Application number: 2024/91427	
What is the application for?:	Listed Building Consent for demolition of rear extension, replacement windows an
Address of the site or building:	The Old School, Kirkgate, Birstall, Batley, WF17 9HE
Postcode:	WF17 9HE

User comments

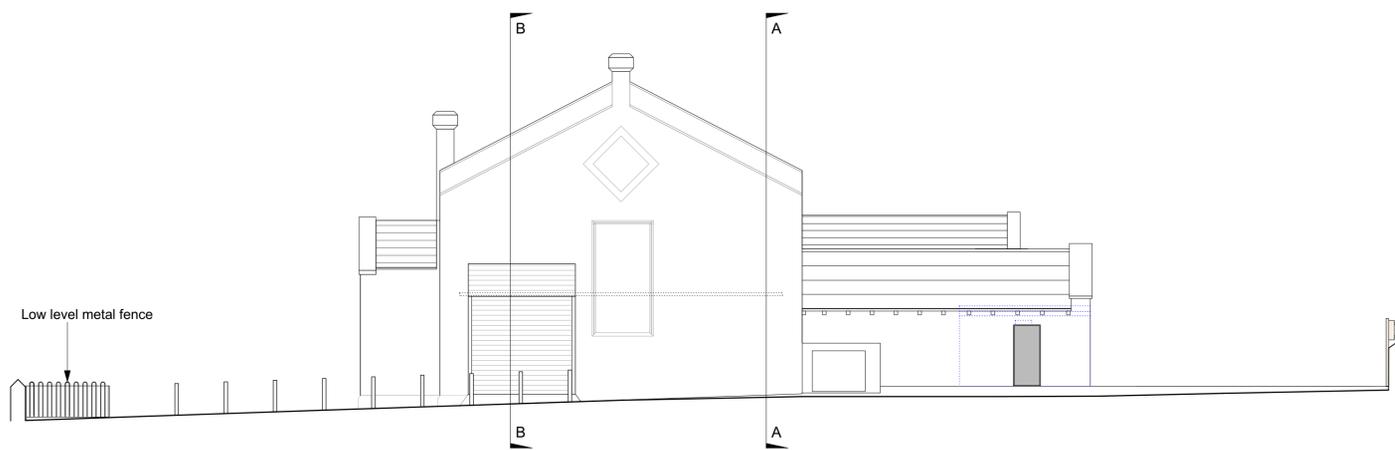
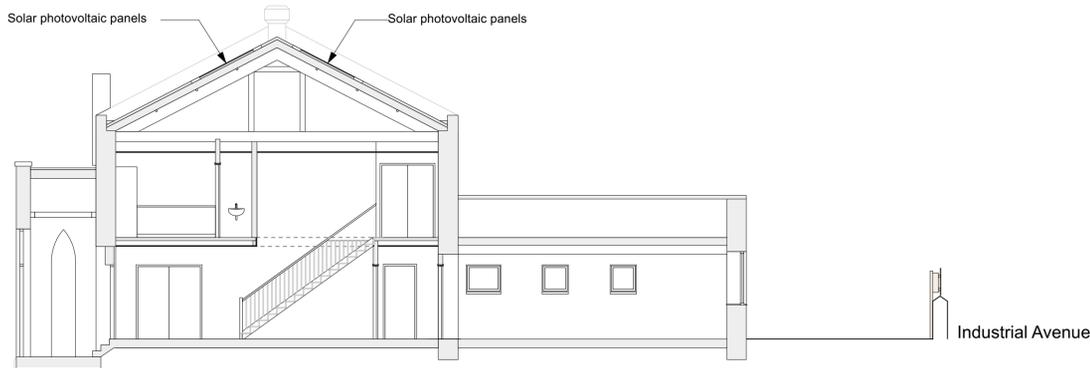
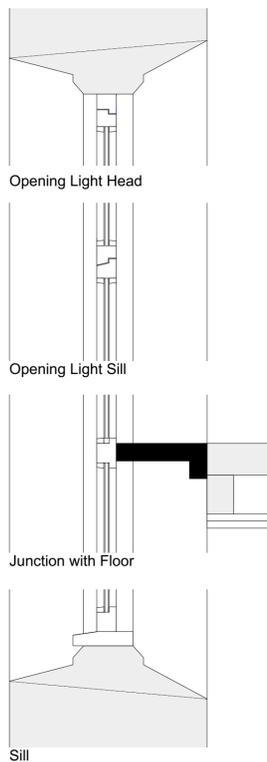
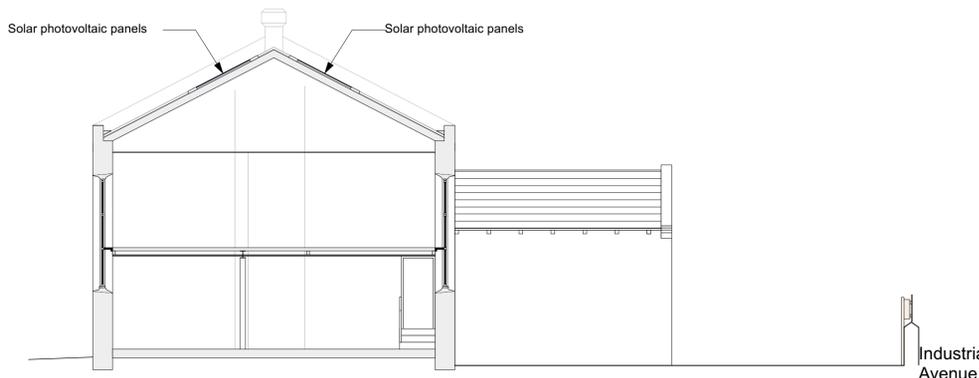
Type of comment: An objection	
Do you wish your comments to be published on the website anonymously?	<input type="checkbox"/> Yes
As a resident facing the rear of the building, I feel the proposed fence (on which works has already started), is far too high and is not in keeping in character of the wall to which it is already attached to. Furthermore it will reduce the light to the front of our houses and the views.
